Your Ref: OWPC22938
Our Ref: BR/76/19/PL 11-03-2019
Please ask for:
Stuart Corbey

13th May 2019

Conversion of existing house into 2 No. 3 bed semi detached properties.
Alloways 33 Shelley Road Bognor Regis

No.	Revision/Issue	Date
Proposed Conversion Proposed Elevations Planning		
Date March 2019		
Scale 1:50

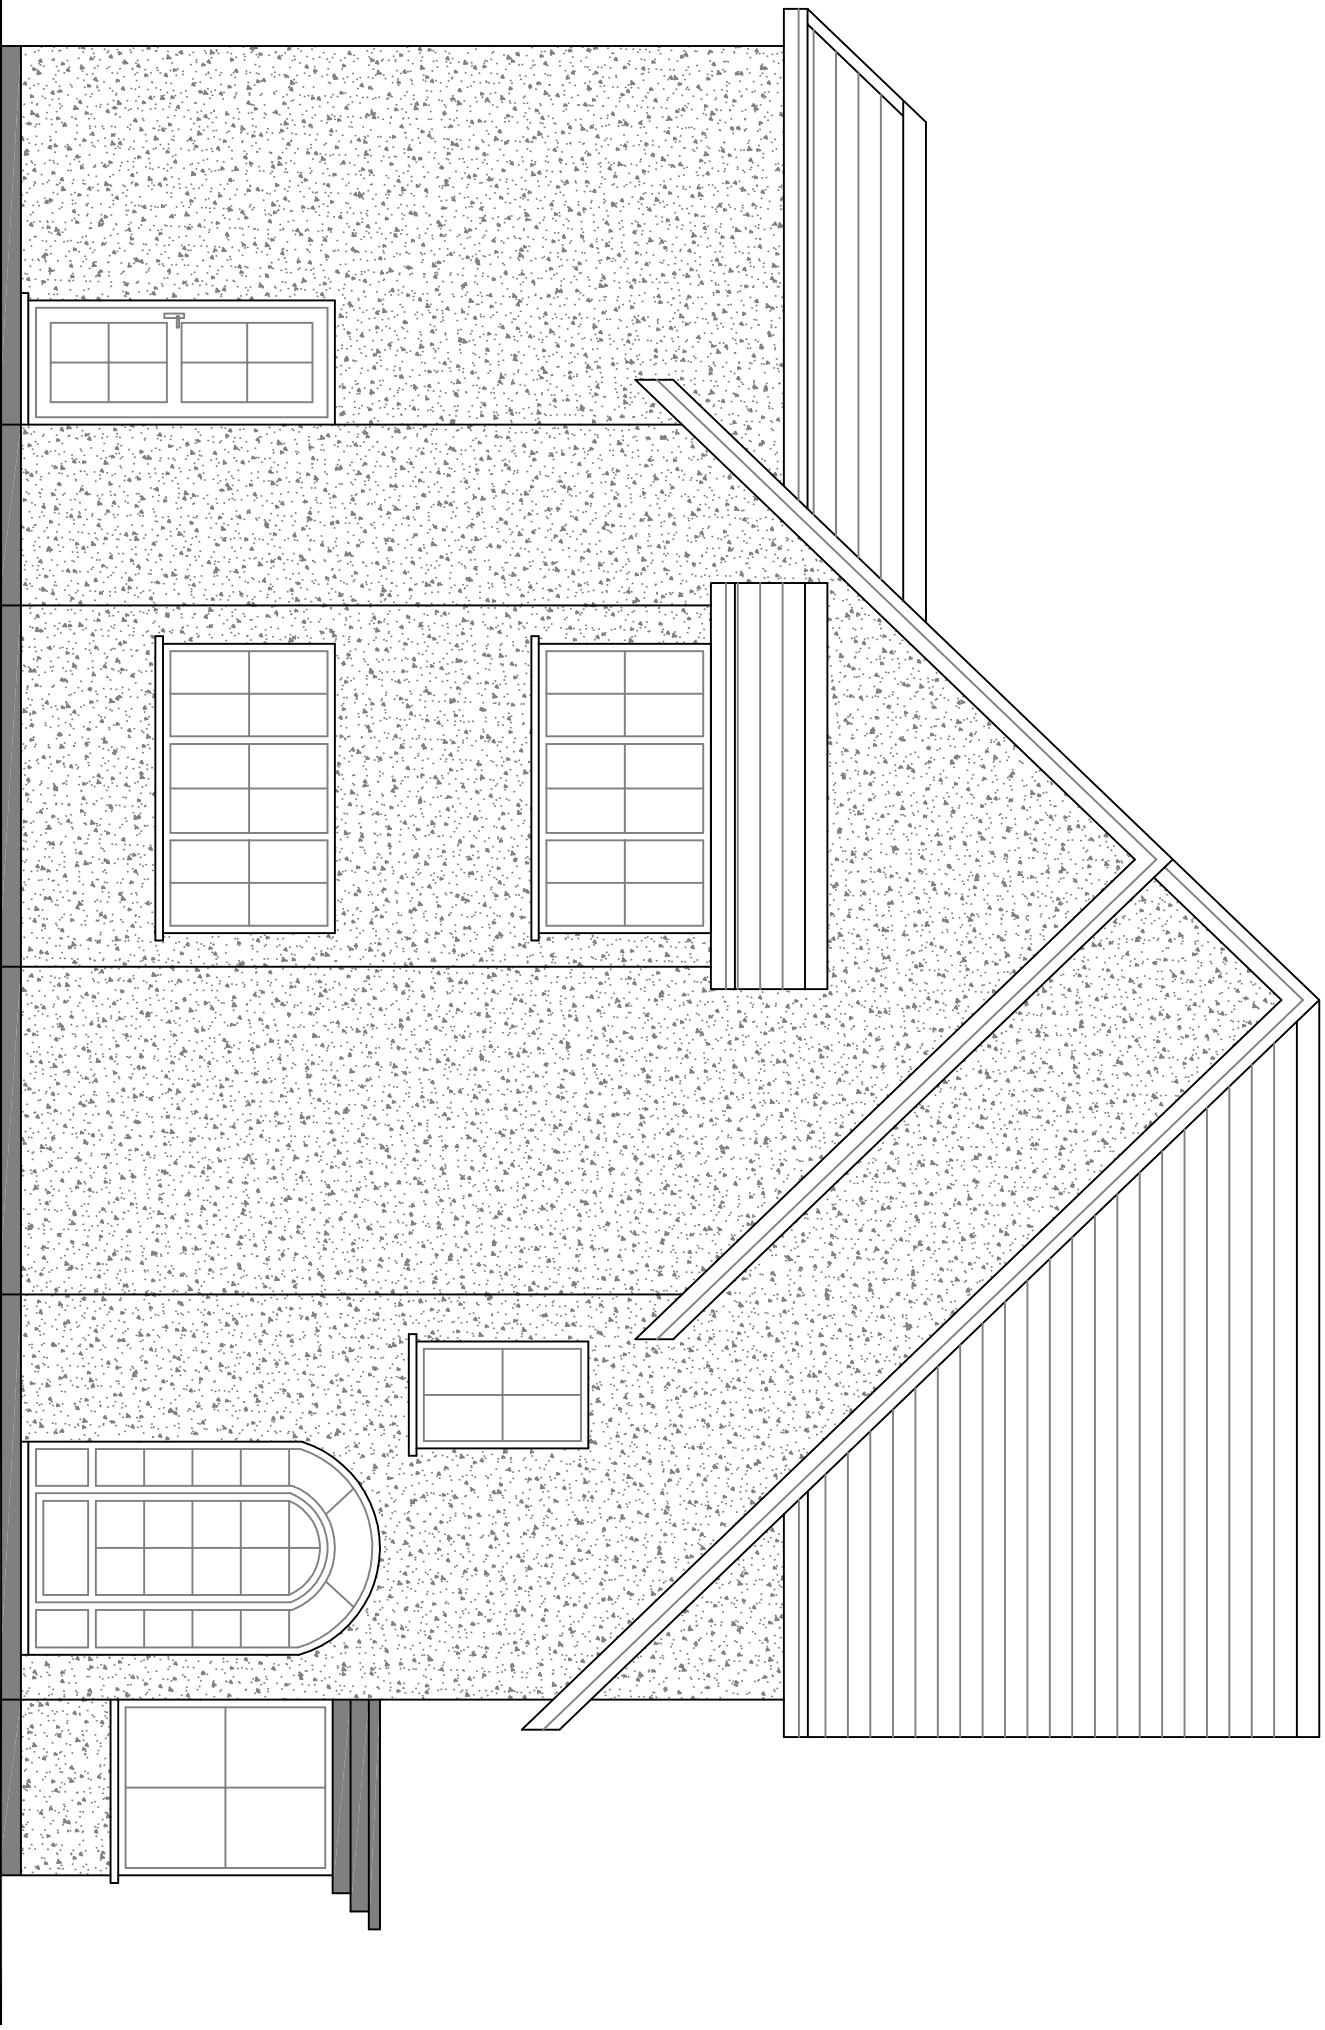
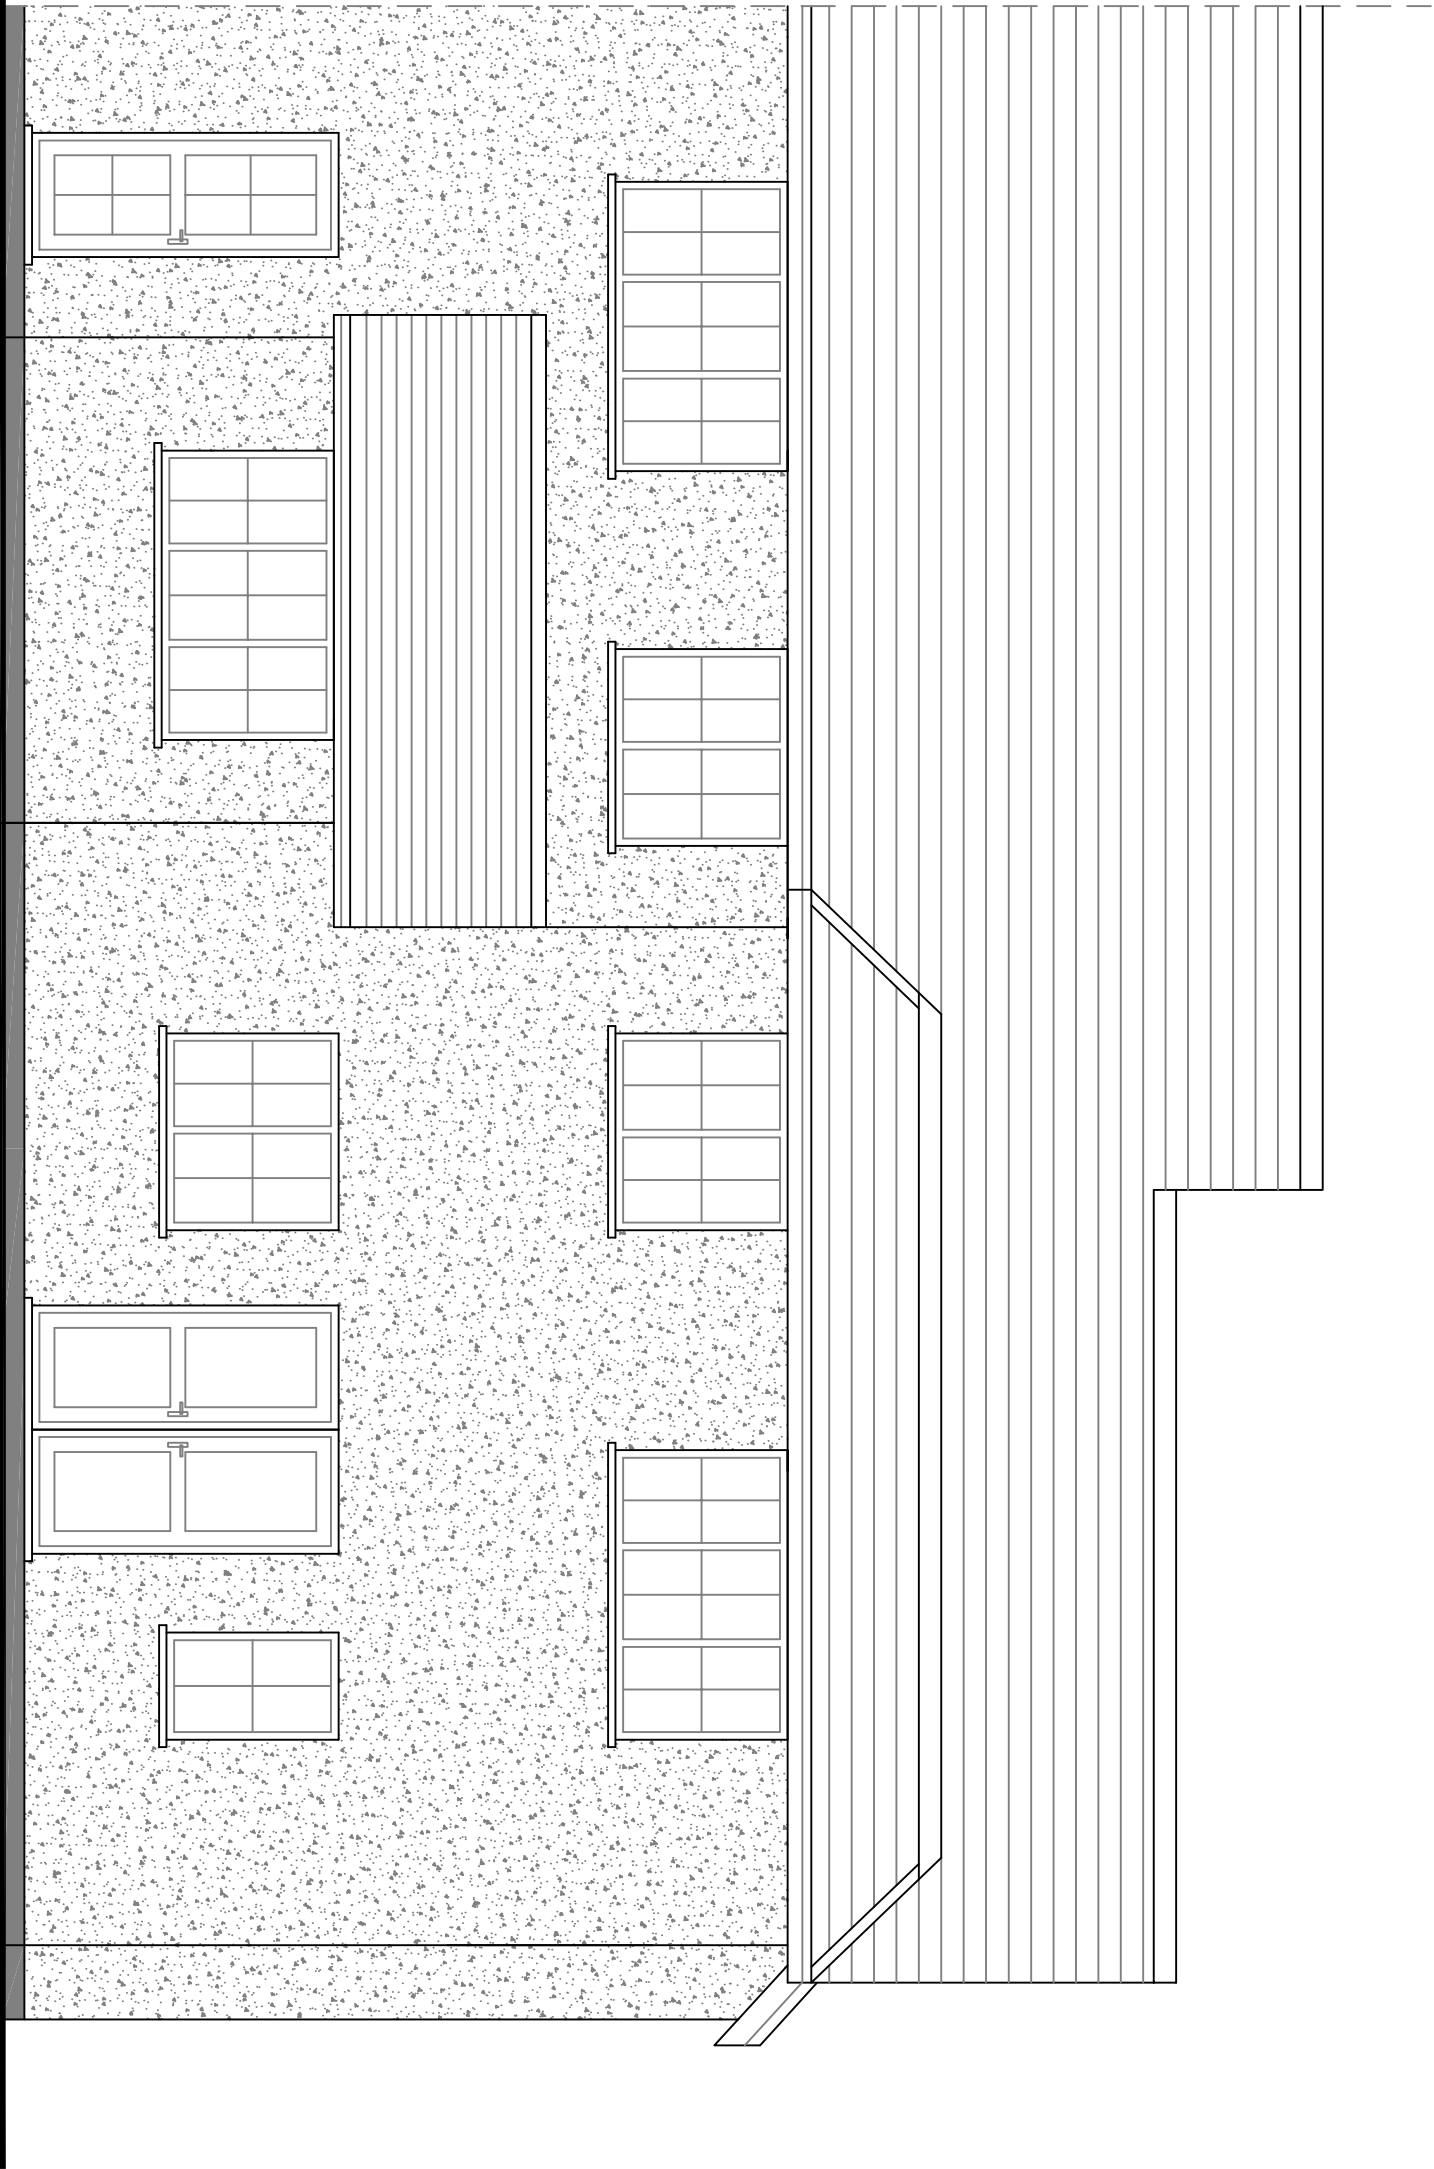
The replacement of the single storey glazed Garden Room on the south and east elevation with a two storey brick and pitched tiled roof extension would result in the substantial loss of natural light into our kitchen, which is served only by a small window opposite the east elevation just fore of the Garden Room door. The side paths between both properties are narrow, but the current flat roofed Garden Room, which is glazed on the East Elevation as well as the south, and incidentally is incorrectly shown on the Existing Elevation Plans (Existing East Elevation) as having no windows aft of the door, allows light to enter our kitchen from both above and through it. We are a multi-generation household and our kitchen is in constant use throughout everyday. It is the most used and important room of the house. As the window is small, light in our kitchen is already at a premium, and additional loss would render it unuseable without constant electric lighting. We do not have any window dressing for this very reason. The loss of light would severely impact our use and enjoyment of the property, and we would suffer financial loss if forced to try and sell as a result of having a kitchen with near no natural light.

A compromise would be to reduce the size of the first floor extension above the Garden Room so that it is stepped in from the east elevation, creating a smaller third bedroom at the rear, or else exclude the rear bedroom and restrict the conversion to two bedrooms. The first floor bathroom could still be created as proposed.
